RE – Yass Valley Wind Farm Preferred Project Report response (our ref. 4743)

Thank you for providing the OEH comments regarding this project, addressed to Department of Planning and Infrastructure, dated 29 August 2013.

ISSUES AND APPROACH OVERVIEW

TITLE
 EA & PPR
 Turbine Layout
 Comparison

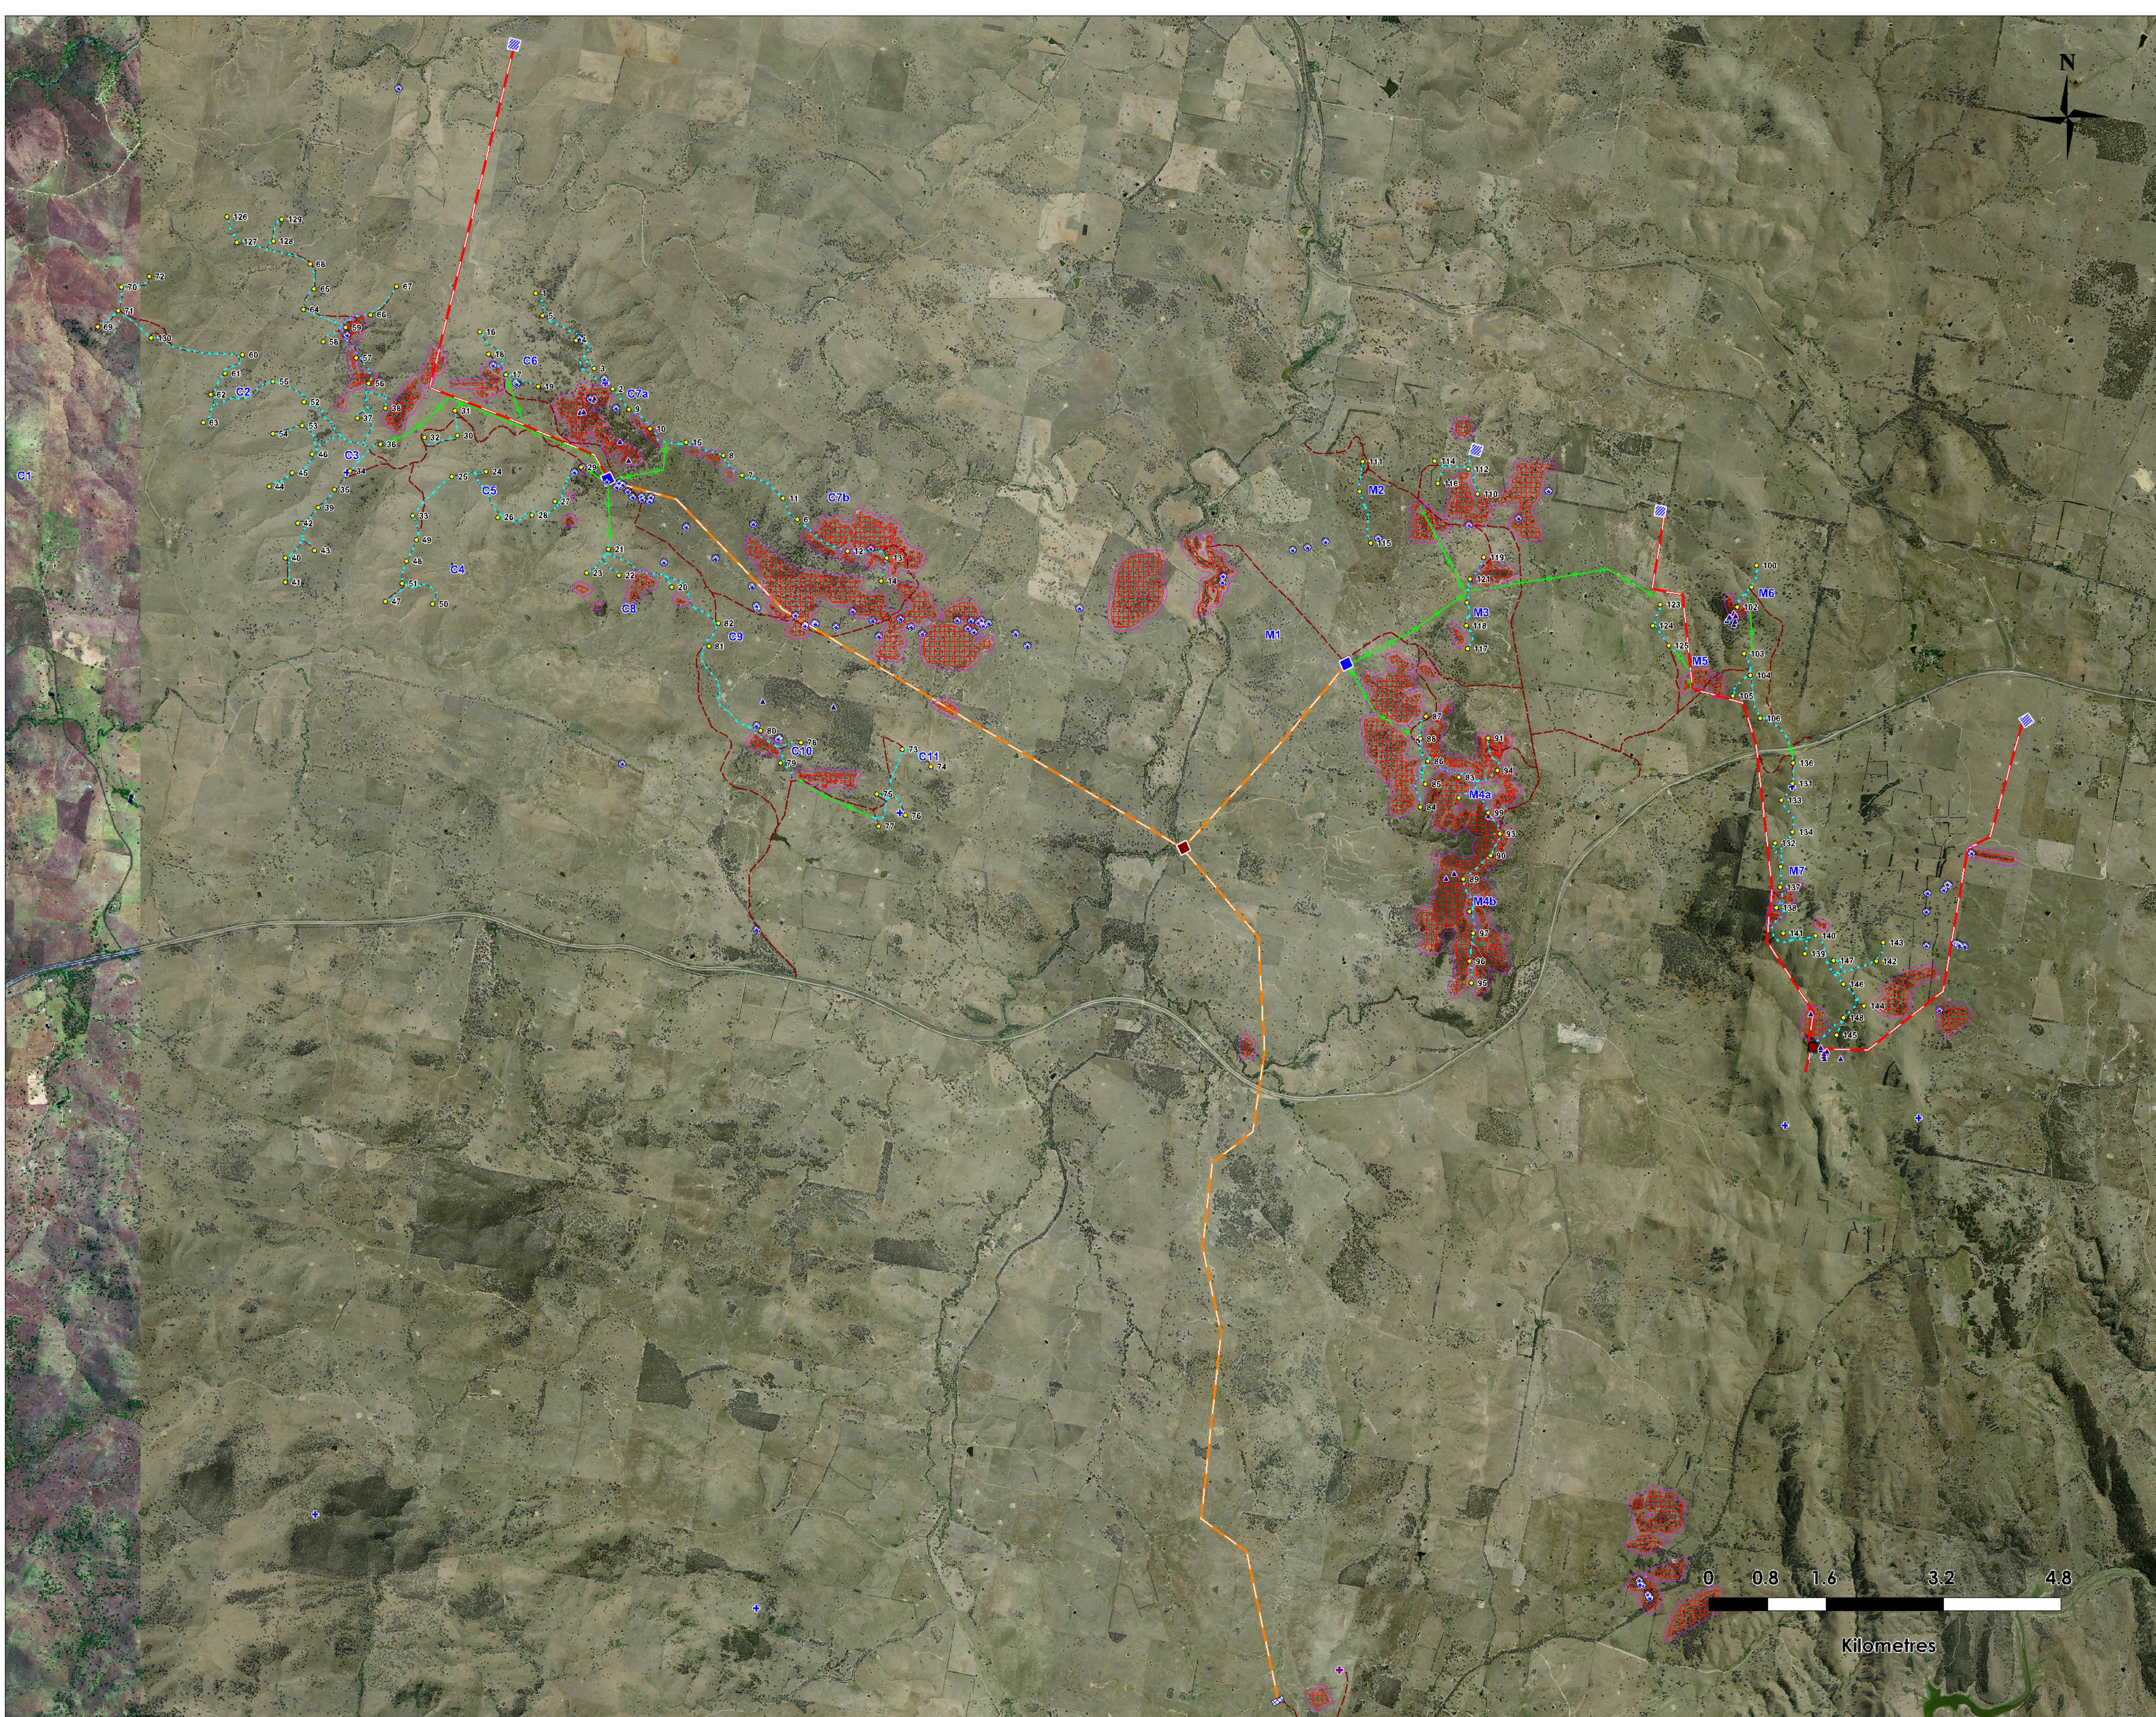
OEH issue	Comment / clarification	Suggested timing and approach
	<p>Where uncertainty exists with regard to impacts, and as a further opportunity to minimise impacts, we regularly recommend that micro-siting be undertaken with input from an ecologist. Examples in this proposal include, to minimise impacts on better quality areas of Box Gum Woodland EEC. This allows a response based on the specific survey findings. Specific protocols would be detailed within the BMP. Reporting and auditing, to ensure all conditions of consent have been met, are also part of the draft standard conditions for wind farms.</p>	
New positions or turbines relative to constraints	<p>OEH require a map showing the new positions or turbines relative to the areas mapped as high constraint in the original EA, to understand how the changes to the layout have reduced biodiversity impacts.</p>	<p>Pre approval New map provided.</p>

1. Layout comparison EA vs PPR layout, showing changes in turbine layout since the publically exhibited EA.
2. Vegetation types Updated vegetation mapping to show ‘worst case’ clearing estimate of EEC vegetation:
 - Areas of ‘pasture’ and ‘exotic’ vegetation have been moved in to Box Gum Woodland in poor-moderate condition, as a precautionary treatment, in advance of detailed field validation.
 - EEC in ‘moderate to good biometric condition’ has been outlined.

TITLE
Biodiversity
High constraint areas

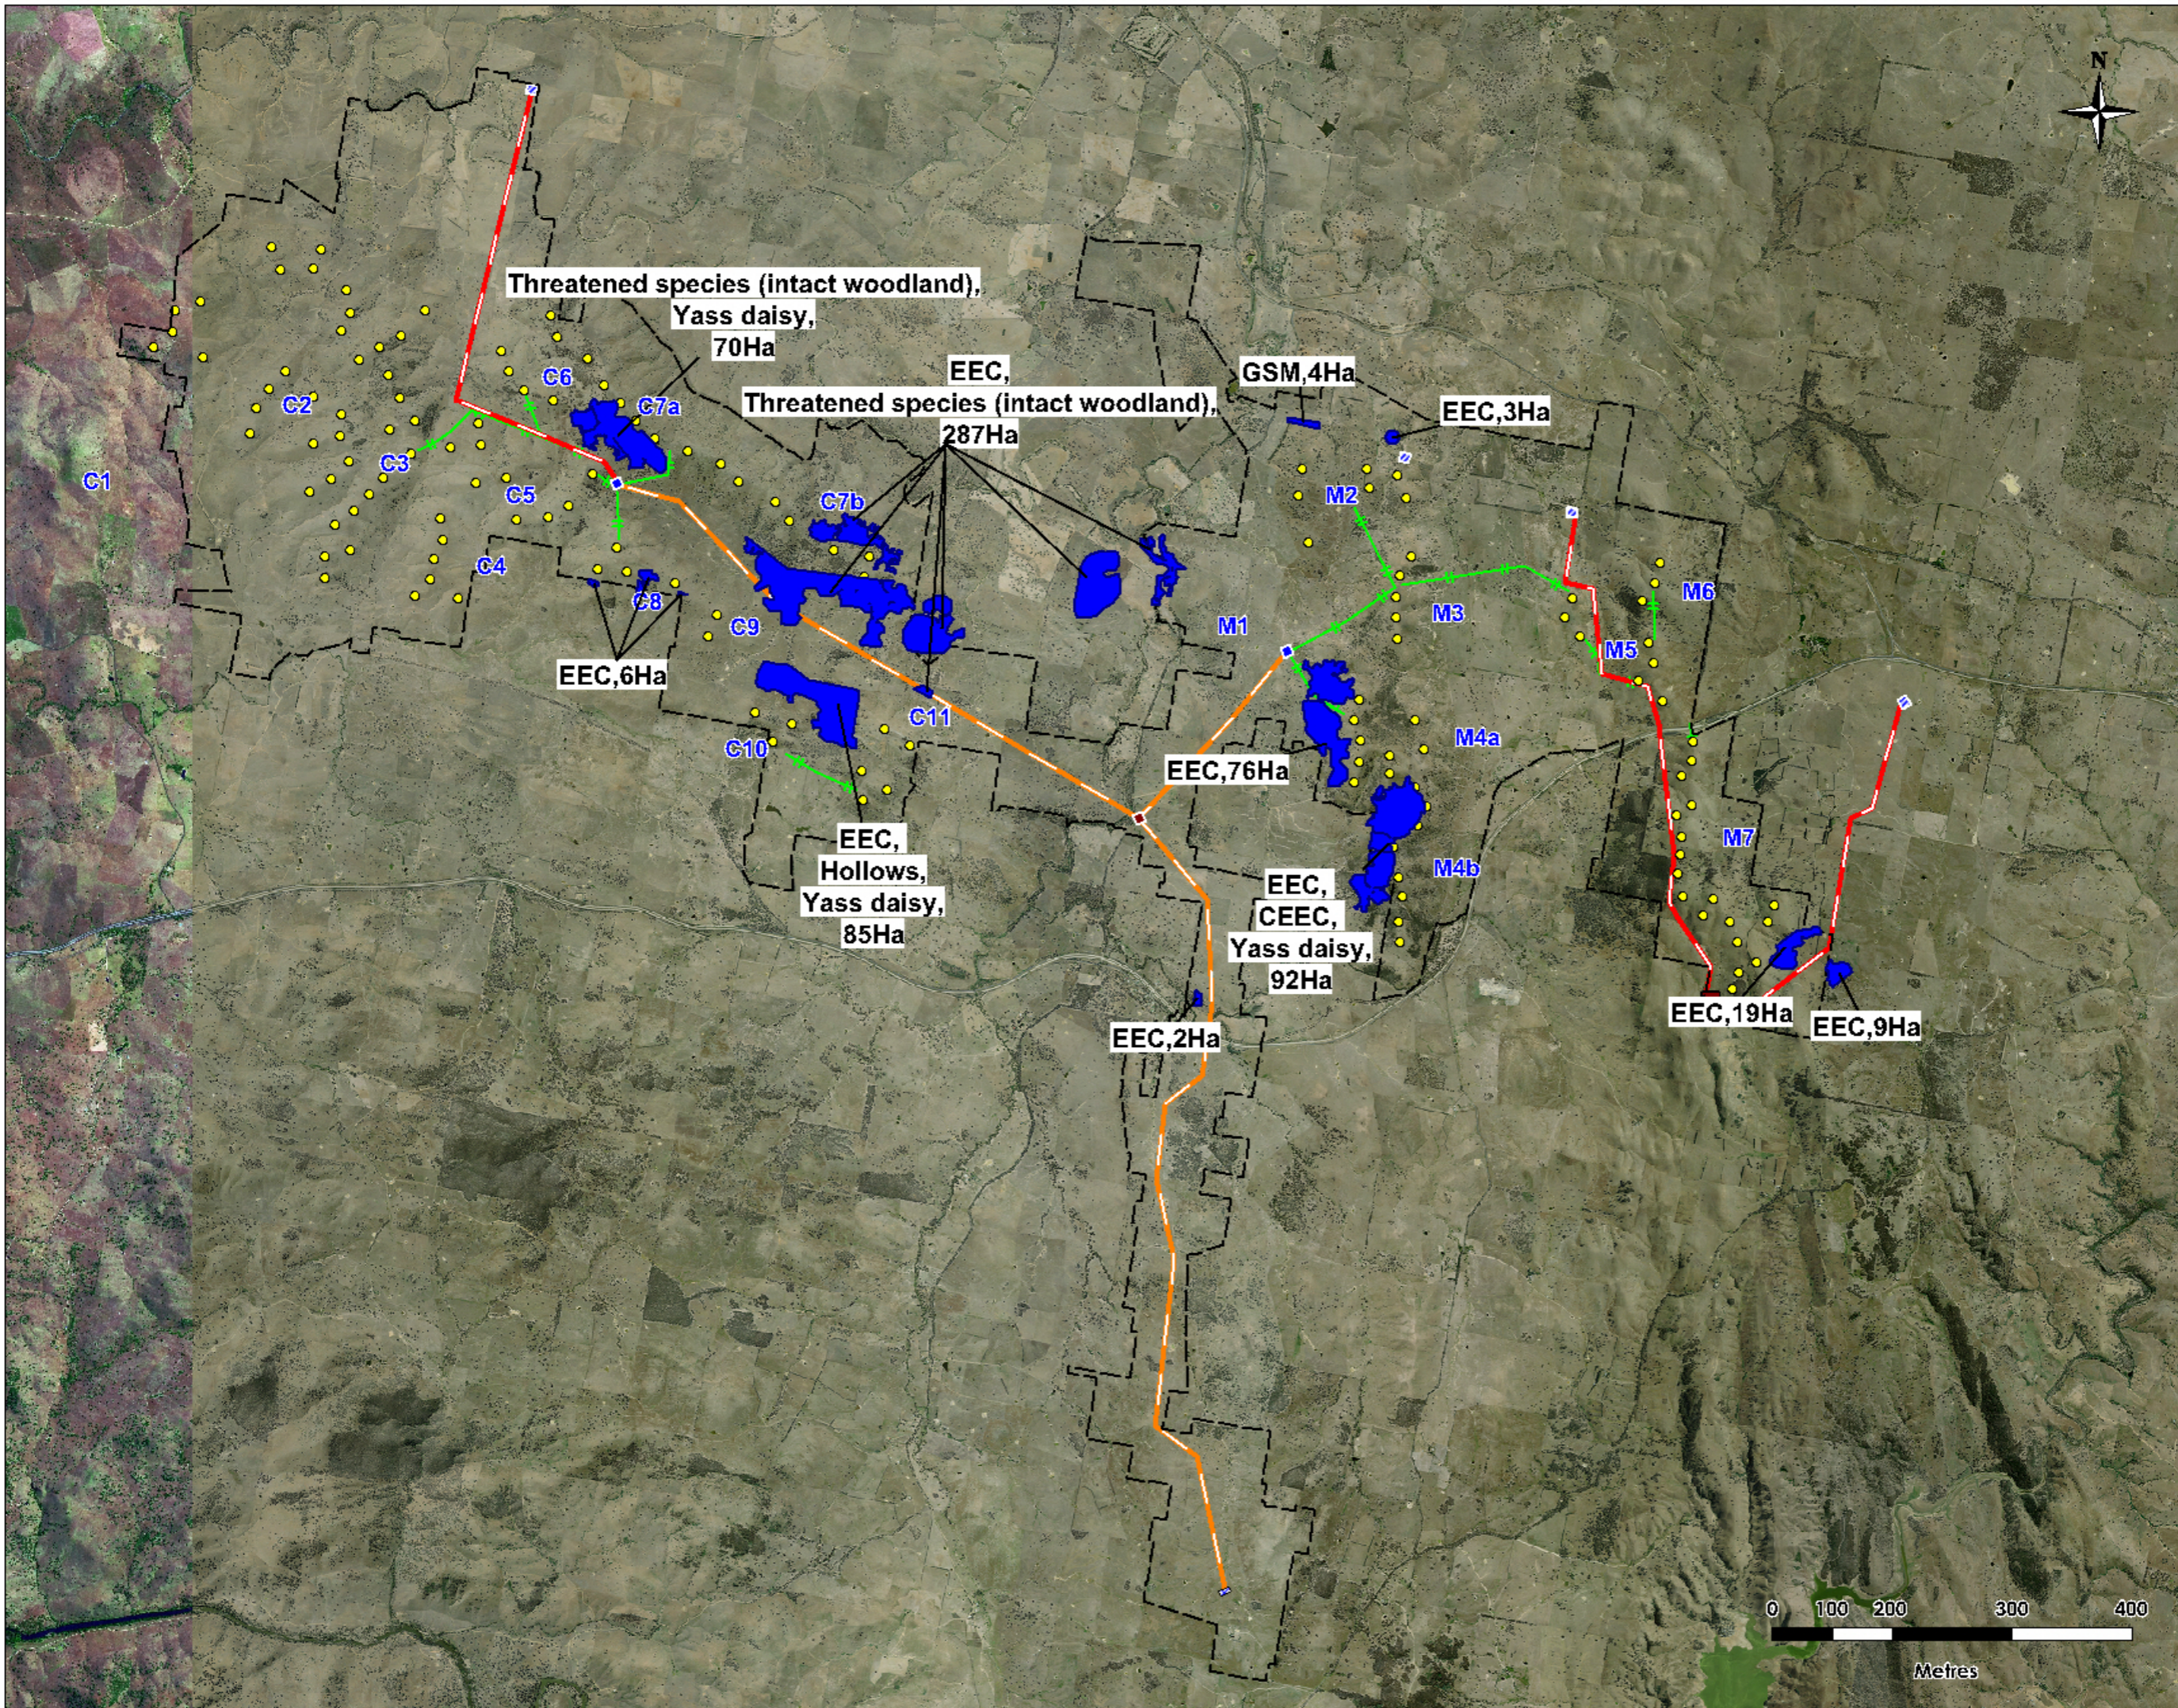
<p>OEH contend that some areas mapped as moderate constraint should be high constraint and avoided. In their letter they use 'high constraint' synonymously with 'high conservation significance'. Our classification of constraints categories is not only based on whether an area is an EEC or provides threatened species habitat, but on whether the type of impact expected could generate a significant impact to a listed entity or an impact that cannot be withstood without local population consequences. Hence we have areas of EEC in moderate to good condition that we contend the removal of would not constitute a significant impact and could be offset, albeit at a high offset ratio. The same vegetation qualities could be deemed a high constraint when near a turbine (and should be avoided) or a moderate constraint, when near a transmission line (to be minimised, managed and offset), due to the difference in impacts expected. The complexity of this has led to a misunderstanding regarding the definition of high conservation value areas.</p> <p>In discussion with Mark Henery, October 2013, we clarified the statements in OEH's submission regarding areas of high conservation significance and areas nominated</p>	Level of constraint	Colour	Description	High constraint	Red	Impacts in these areas may be significant and should be avoided. Impacts cannot be offset or may be very costly to offset. Further assessment may be required to inform impact significance.	Moderate constraint	Orange	Impacts to these areas should be minimised and/or will require specific measures to manage impacts. Residual impacts should be offset.	Low constraint	Green	No specific mitigation measures required – development most appropriate located in these areas.	<p>Pre approval</p> <p>Using the updated vegetation maps (discussed above), updated constraints mapping is proposed, in consultation with OEH. High constraint areas = avoidance, as per the existing statements of commitment. We propose to develop a high constraint shape file in consultation with OEH to ensure the approval includes avoidance in these areas. The scale would be sufficient to show any allowable tracks through high constraint areas.</p> <p>As this mapping will affect the offset requirement and potentially the final infrastructure layout, this is proposed to be done well in advance of construction, with input from OEH. The first draft is supplied with this letter, for consideration.</p> <p>The result will ensure that a final map set can accompany the BMP which marks all high constraints for avoidance, giving certainty to OEH and Epuron, regarding infrastructure placement.</p> <p>Post approval</p> <p>Moderate constraint areas will require detailed protocols, mostly centred on preclearance surveys to relocate, minimise harm and / or ensure an offsetting requirement is recorded. They would be mapped as part of the BMP but are not proposed to be mapped at this stage. They would include rocky outcropping, trees greater than 40cm dbh, Golden sun moth habitat.</p>
Level of constraint	Colour	Description												
High constraint	Red	Impacts in these areas may be significant and should be avoided. Impacts cannot be offset or may be very costly to offset. Further assessment may be required to inform impact significance.												
Moderate constraint	Orange	Impacts to these areas should be minimised and/or will require specific measures to manage impacts. Residual impacts should be offset.												
Low constraint	Green	No specific mitigation measures required – development most appropriate located in these areas.

OEH issue	Comment / clarification	Suggested timing and approach
	<p>as high constraints to be avoided. OEH do not intend to infer that all areas of EEC, regardless of condition, should be avoided. The key issue in moving forward is agreeing which areas within the site boundary constitute high constraints to be avoided. This is a judgment call that we intend to make in consultation with OEH, to deliver revised constraints mapping for the project.</p> <p>To start this process, the following areas will be mapped as high constraint (to avoid) on the advice of ngenvironmental. Epuron will finalise this mapping with input from OEH.</p> <p>High constraints from the BAs and SER are mapped. This includes:</p> <ul style="list-style-type: none"> • WF site (BAs): <ul style="list-style-type: none"> ○ EEC in ‘moderate, moderate to good and good’ condition ○ Woodland fauna and threatened fauna habitat ○ Marked hollow bearing trees (not exhaustive) • TX line (SER): <ul style="list-style-type: none"> ○ EEC in ‘moderate to good and good’ condition ○ Likely movement corridors in woodland and forest ○ Threatened species habitat <p>And additionally:</p> <ul style="list-style-type: none"> • Yass Daisy locations with 5m buffer. <p>It is noted that the impact of turbines within high constraint areas is not the same as tracks or transmission infrastructure. Some fine scale mapping has been undertaken to allow minimum width tracks in high constraint areas. In these areas, minimising impact on overstorey vegetation can be seen to have been achieved. Where transmission lines occur in high constraint areas, pole footings can be placed either side of the high constraint boundary or in a way that avoids tree clearance.</p>

3. High constraint High constraints from the BAs and SER are mapped. This includes:
 - WF site (BAs):
 - EEC in ‘moderate, moderate to good and good’ condition

- Woodland fauna and threatened fauna habitat
 - Marked hollow bearing trees (not exhaustive)
 - TX line (SER):
 - EEC in ‘moderate to good and good’ condition

- Likely movement corridors in woodland and forest
 - Threatened species habitat

- Yass Daisy locations with 5m buffer.

It is noted that the impact of turbines within high constraint areas is not the same as tracks or transmission infrastructure. Some fine scale mapping has been undertaken to allow minimum width tracks in high constraint areas. In these areas, minimising impact on overstorey vegetation can be seen to have been achieved. Where transmission lines occur in high constraint areas, pole footings can be placed either side of the high constraint boundary or in a way that avoids tree clearance.
4. Potential offset sites Potential offset areas include connected mature woodland, EEC and threatened species habitat.
